A303 Amesbury to Berwick Down

**8.4(1) - Statement of Common Ground –
National Farmers Union (TRACKED CHANGES)**

STATEMENT OF COMMON GROUND – National Farmers Union

Version	Date	Status of Version
Rev 0	03.05.2019	Deadline 2 Issue
Rev 1	09.08.2019	Deadline 7 Issue

Drawing Title
**RIGHTS OF WAY AND ACCESS PLANS
REGULATION 5(2)(k) & 5(2)(o)
SHEET 4 OF 15**

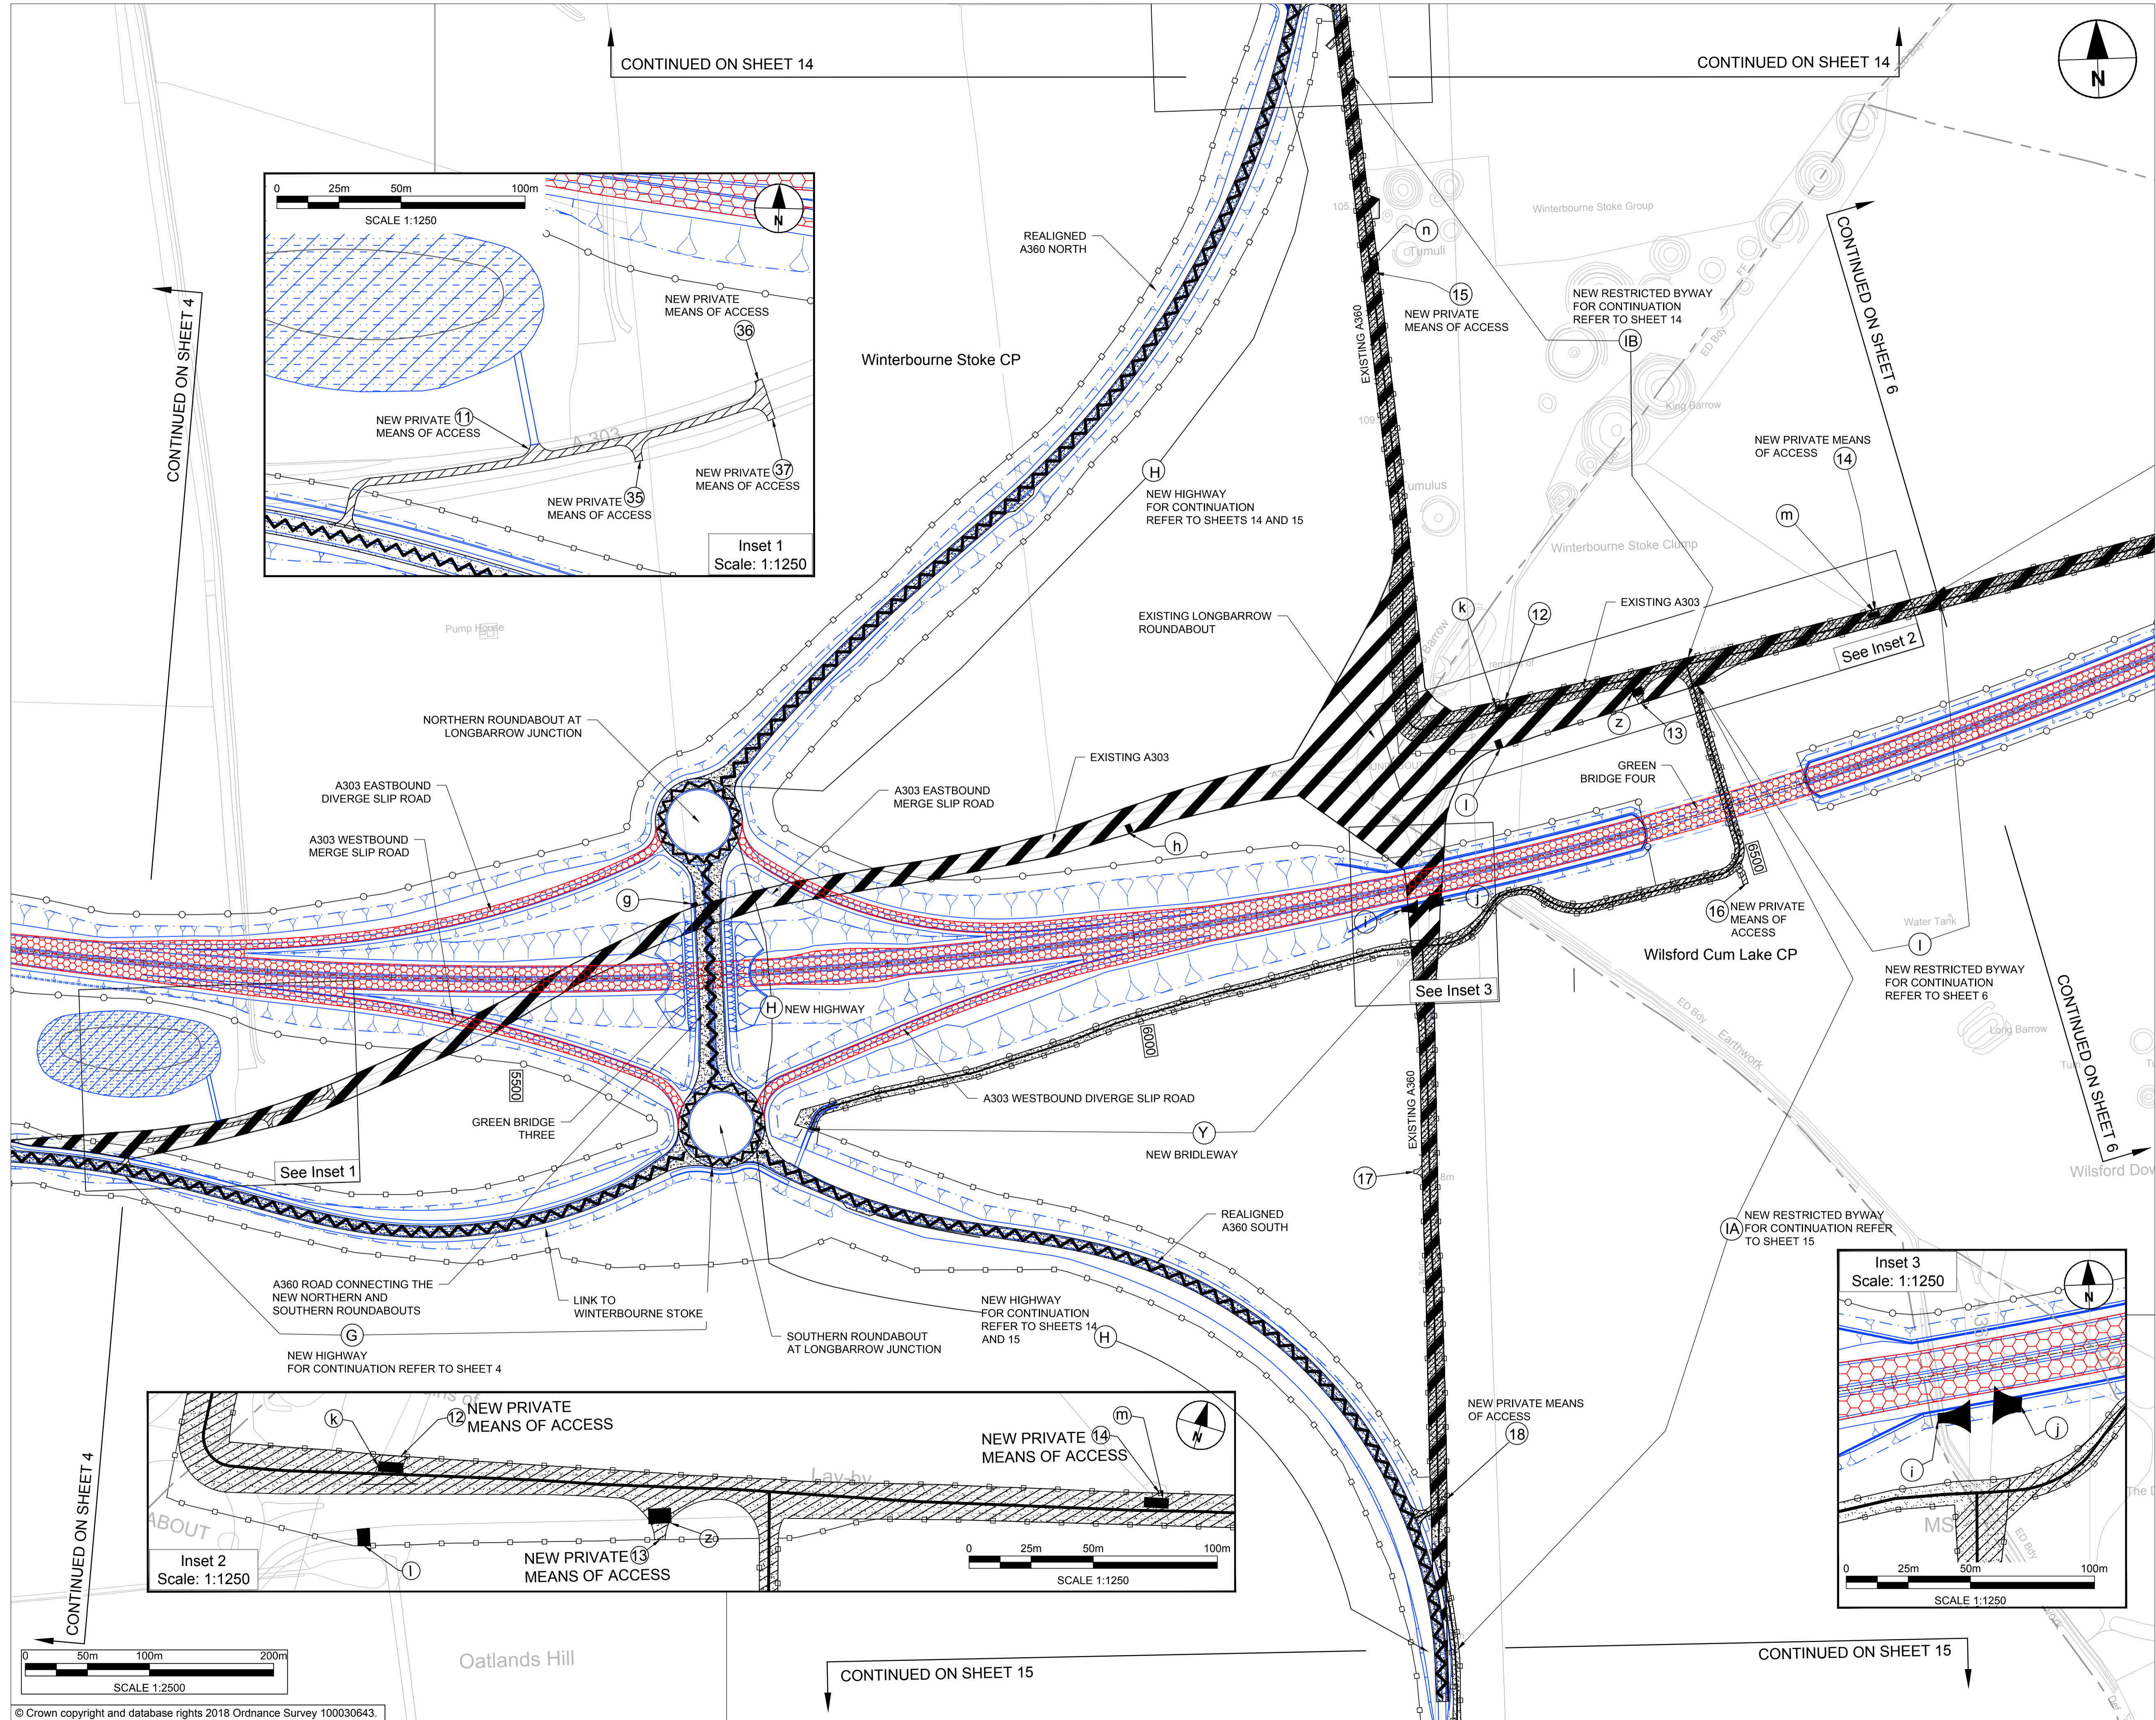
the draft DCO [REP6-005] sets out that a 1.5m high environmental barrier must be provided by the Scheme along the southern aspect of the River Till bridge.	
<u>3.19</u>	<u>ES Chapter 11- Road drainage and the water environment [APP-049]</u>	<u>11.3 Assessment methodology (and Appendix 2.1)</u>	<u>11.3.10 – 11.3.13 Consultation</u>	<p><u>Further information is needed in regard to the size and location of the drainage infiltration.</u></p> <p><u>Concern: The locations are greatly interfering with farm operations within fields.</u></p> <p><u>Solution: A new access route has been highlighted. This is not necessary and access could be created from the byway at green bridge no.2. (Turners)</u></p>	<p><u>Following this consultation feedback, the number of drainage infiltration areas has been rationalised in the application Scheme in terms of reducing the number from five to four and locating them closer to the new road. Due to the reduced number, each infiltration area needs to be slightly larger to meet the storage capacity requirement and to provide permanently wet areas to create dew ponds and allow for biodiversity enhancements.</u></p> <p><u>Access to the infiltration pond by Green Bridge 2 on the northern side of the A303 will now be accessed from the byway. Access to the pond on the southern side of the new road, by the viaduct, will be taken from a track within the field margin. The revised proposals can be seen within APP-009 2.6 Rights of way and access plans (sheet 4).</u></p>	<u>AGREED</u>
